Ribble Valley Borough Council
By email

Your ref 3/2024/0942
Our ref DC/25/281
Date 24-FEB-25

Location: Black Moss Farm Elmridge Lane Chipping PR3 2NY

Proposal: Proposed conversion of two stone barns to create three holiday cottages with associated curtilages.

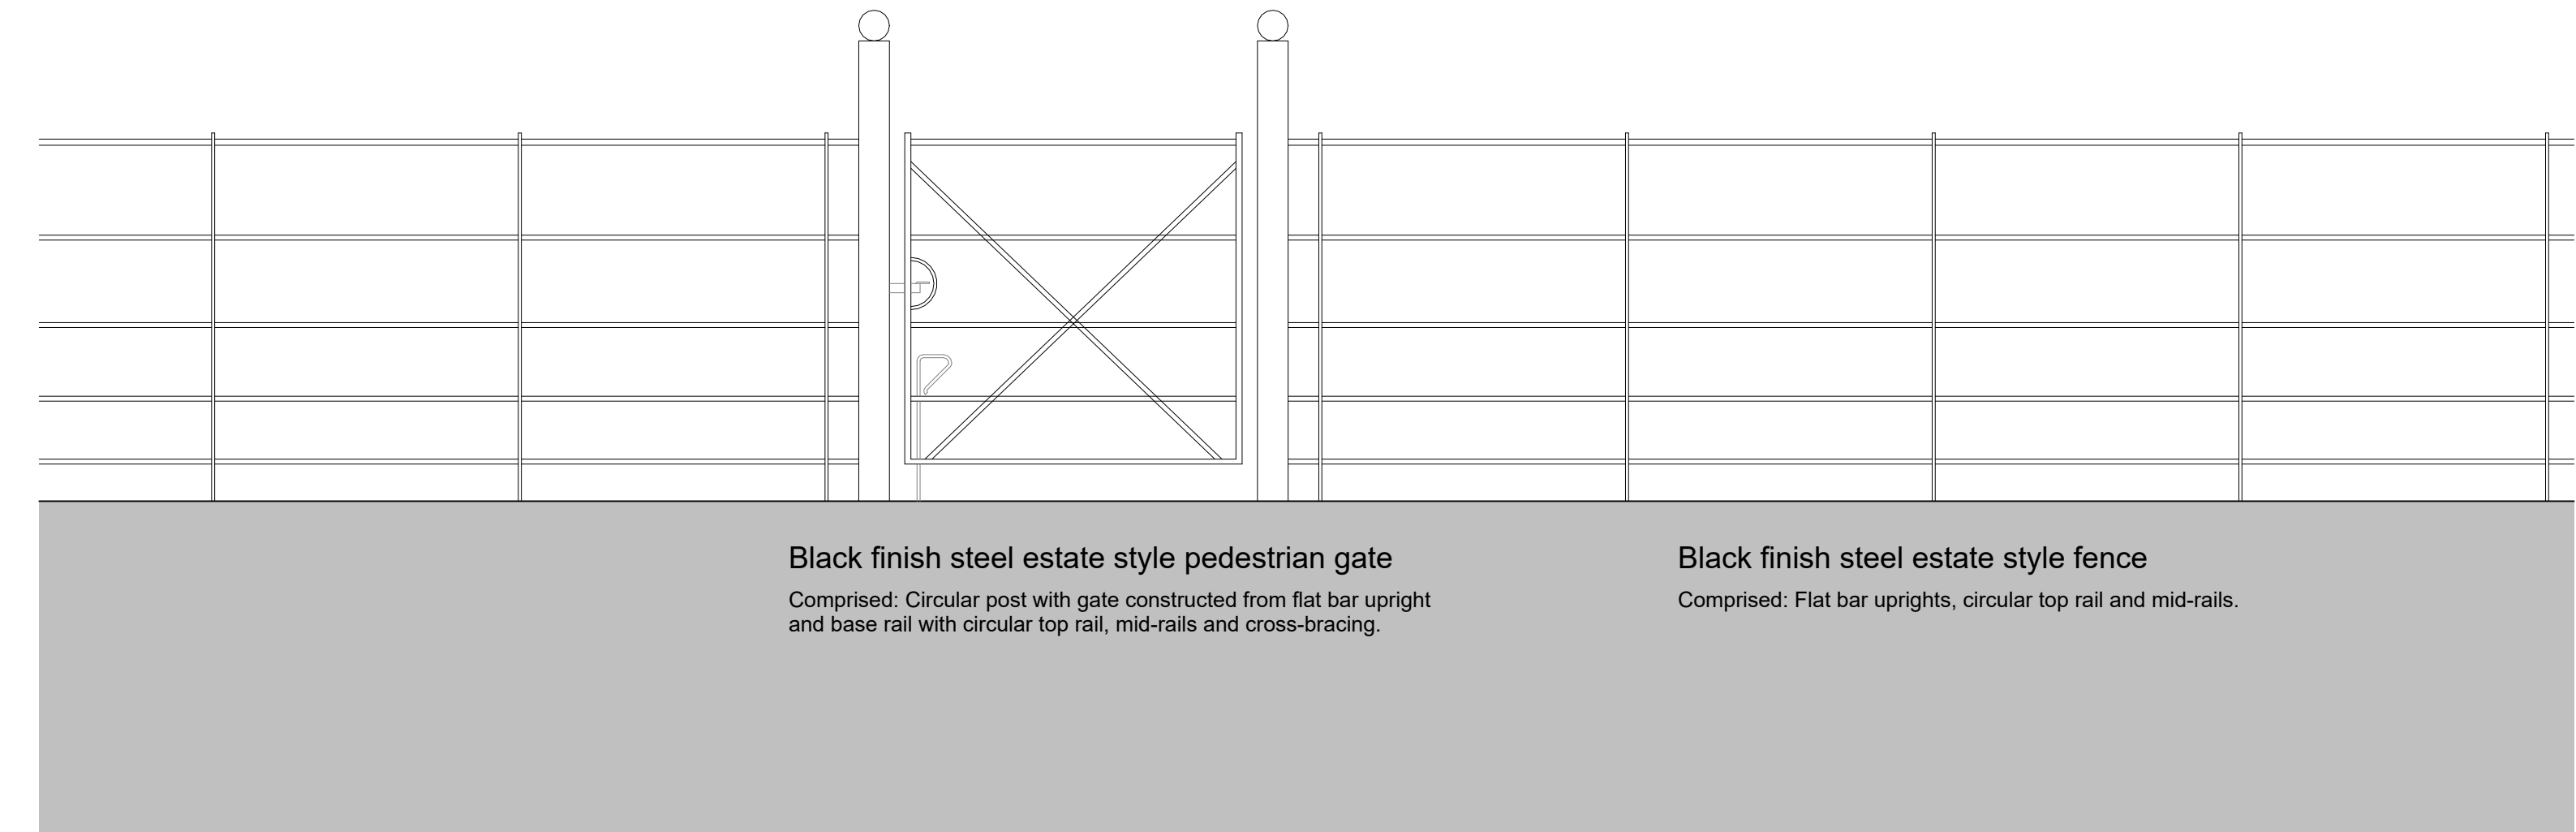
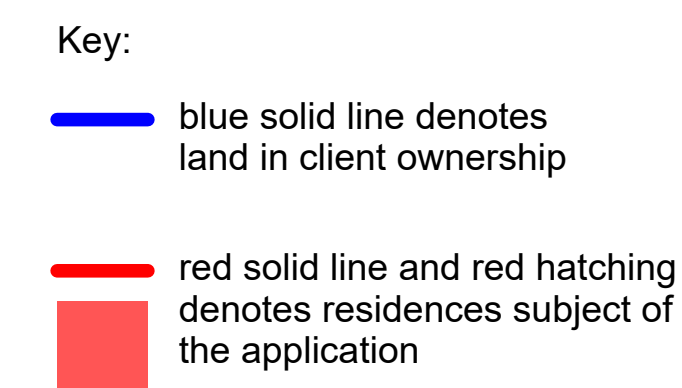
Several water mains including a significant large diameter trunk main, crosses the site. It must not be built over, or our access to the pipeline compromised in any way. We require an access strip as detailed in our 'Standard Conditions for Works Adjacent to Pipelines', which can be found on our website: <https://www.unitedutilities.com/builders-developers/your-development/planning/building-over-or-working-near-our-assets/working-near-our-pipes/>.

Following our review of the proposed site layout, we have concerns regarding the proximity of proposed development to our significant water assets. To demonstrate that this layout can be achieved, and to avoid any unnecessary costs or delays to either the applicant or any future developer, we request the applicant submits a detailed site layout plan which overlays the PROVEN location of all water mains in relation to any proposed development (including walls, fencing, parking etc.). Evidence must be provided to show the location of the pipelines has been confirmed by site specific survey; a copy of asset maps will not suffice. If trial holes are required to confirm the location and depth of the assets instead of GPR, the developer will need to get the prior approval of Developer Services Water, and a United Utilities representative will need to be on site during the trial holes. Therefore, due to size of this significant asset, we request the applicant contacts our Developer Services team by email at DeveloperServicesWater@uuplc.co.uk as soon as possible.

No development shall commence until details of the means of ensuring the water main that is laid within the site boundary is protected from damage as a result of the development have been submitted to and approved by the Local Planning Authority in writing. The details shall include a survey that identifies the exact location of the assets, the potential impacts on the water main from construction activities and the impacts post completion of the development on the water main infrastructure that crosses the site and identify mitigation measures to protect and prevent any damage to the water main both during construction and post completion of the development. Any mitigation measures shall be implemented in full in accordance with the approved details.
